From: Mark Bone [REDACTED]
Sent: 08 February 2013 10:42
To: Julie Grieves
Subject: Re: EG/7/13 - 4 Wandleys Drive

re 4 Wandleys Drive Eastergate

proposed floor plan

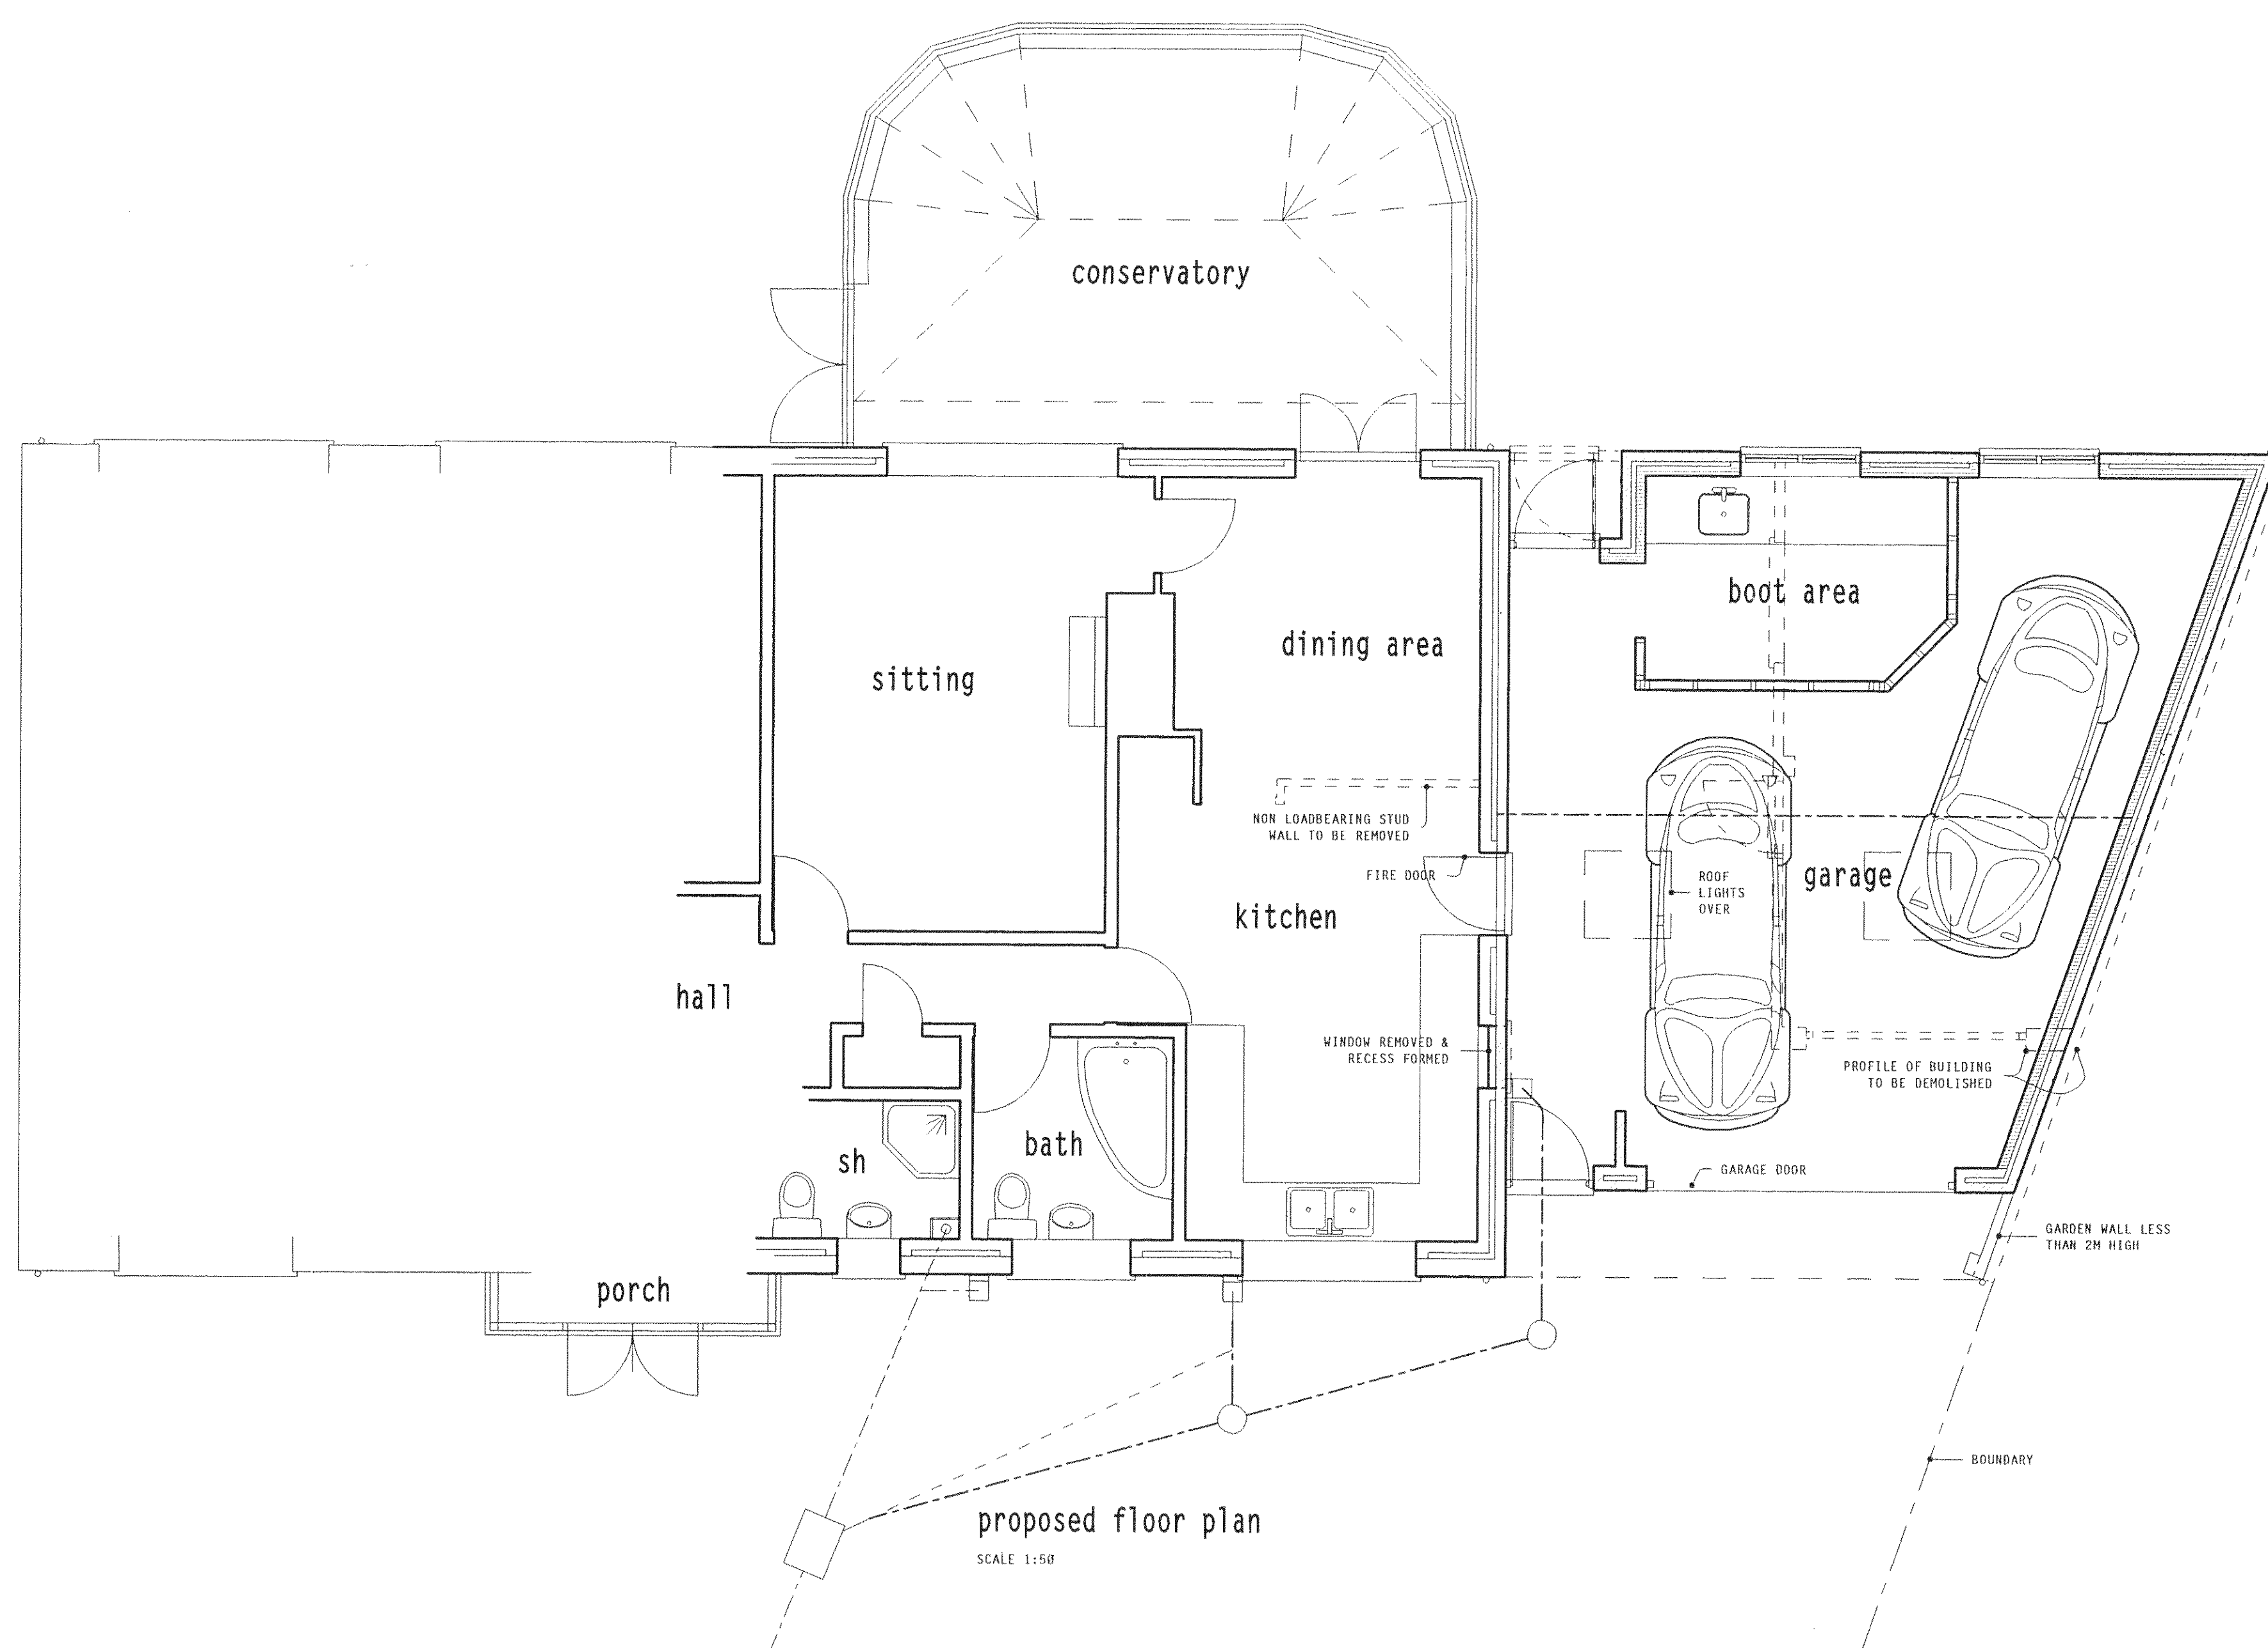
As you are proposing a new sink unit at the above site, please confirm if the drainage is to be connected to the existing mains drainage.

I confirm new sink waste to existing mains foul drainage system.
